From: Maria Tomalova <Maria.Tomalova@arun.gov.uk>
Sent: Wednesday, September 13, 2023 5:27 PM
To: Planning.Responses <Planning.Responses@arun.gov.uk>
Subject: FW: Y/105/19/PL & Y/106/19/L

Y/105/19/PL & Y/106/19/L

The proposal is for the conversion of, and alterations to, existing barns to create 3 dwellings, along with the erection of car barns, a store, a replacement pump house, demolition of a C20 barn and associated landscaping and parking.

Drawing Title	Proposed Plans - Barn 3
Scale	1:100 @ A3

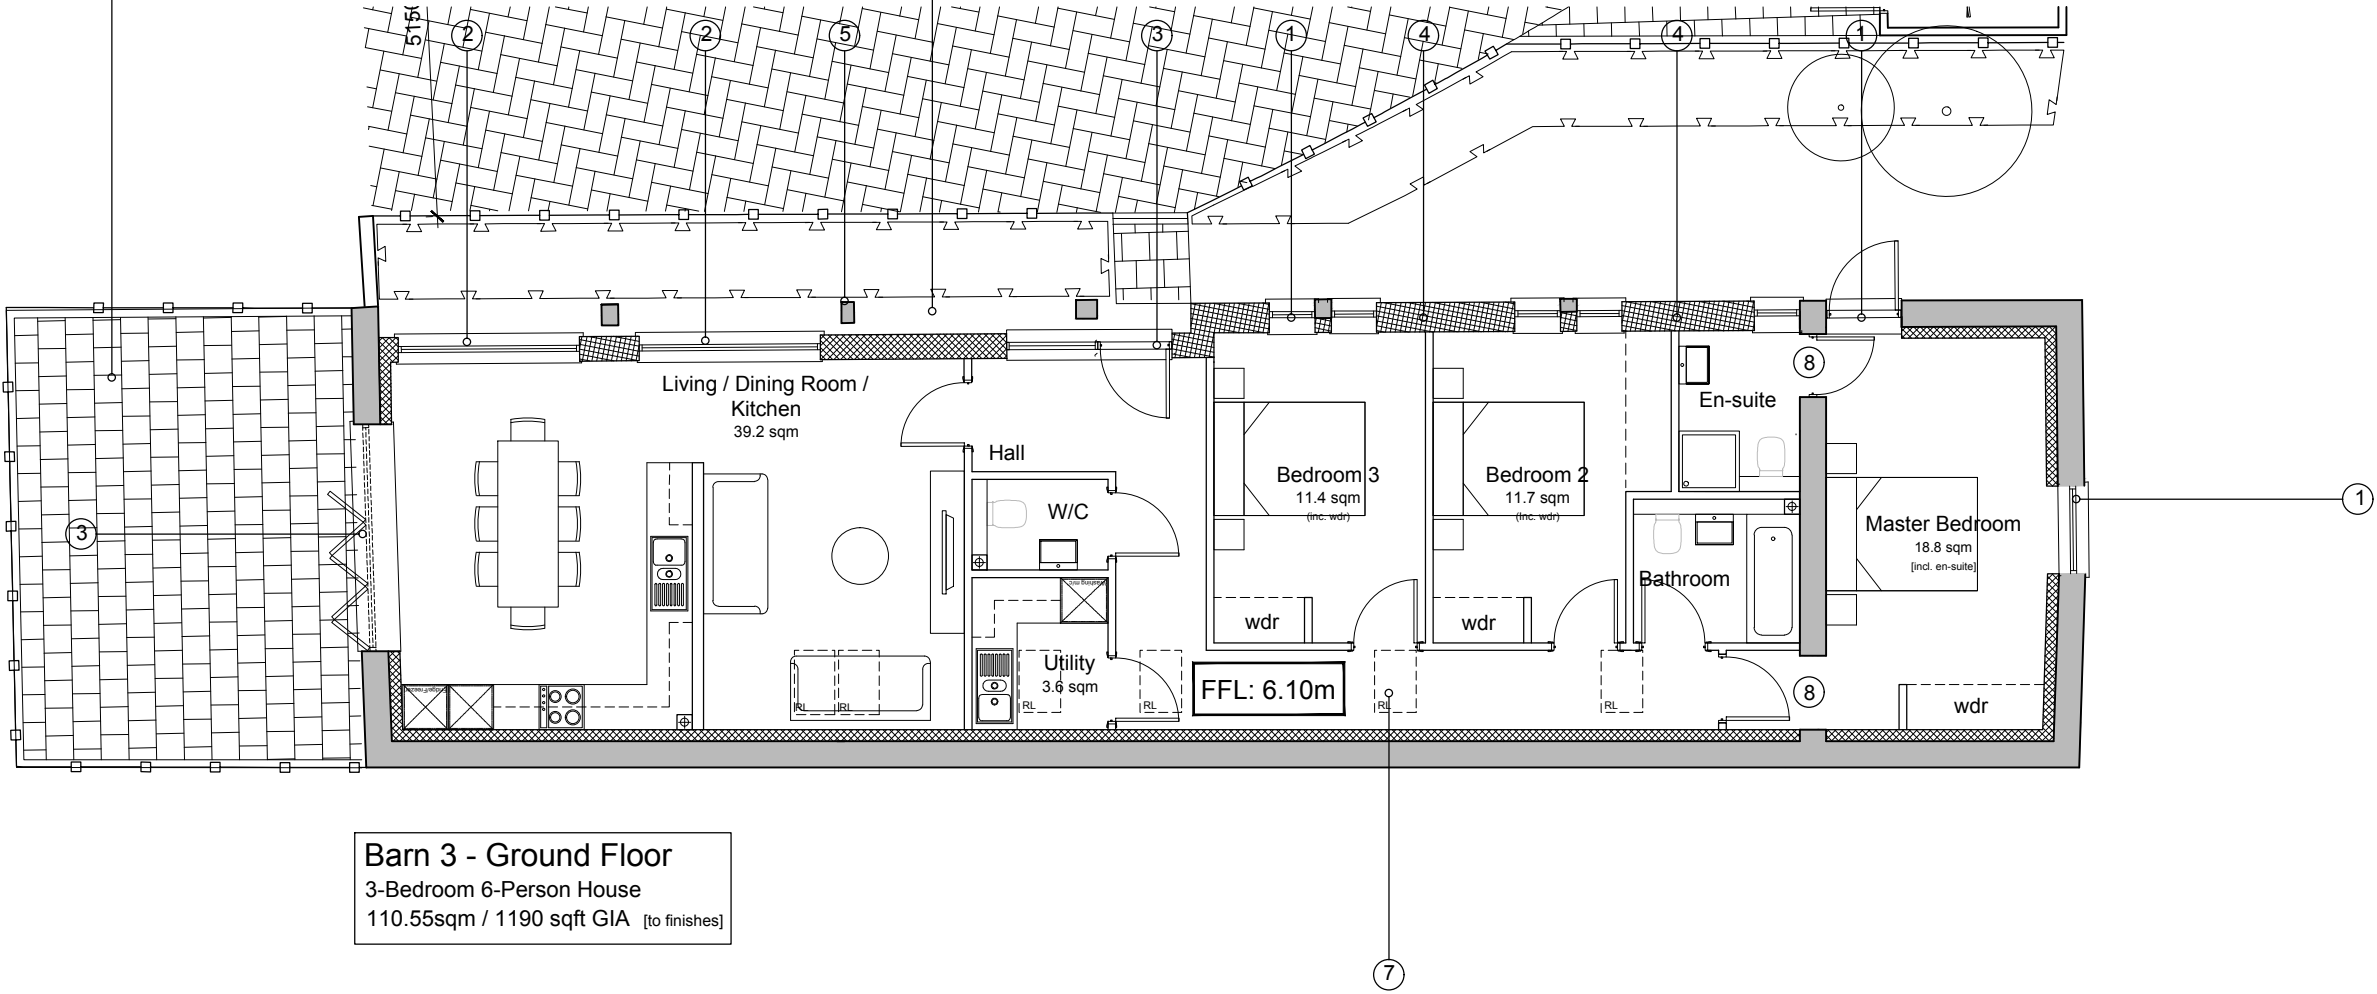
Likewise, it is noted that the building referred to as 'barn 3' is to include bi-folding doors. Such a feature is not normally associated with a barn and cannot be supported here. It is suggested that an alternative approach be considered which would result in the loss of less historic fabric, and a more appropriate design.

Yes, this can be altered to a pair of patio doors which will reduce the size of the opening in the exiting barn. Again, where new external openings are proposed we will look to repurpose the flint elsewhere in the scheme.
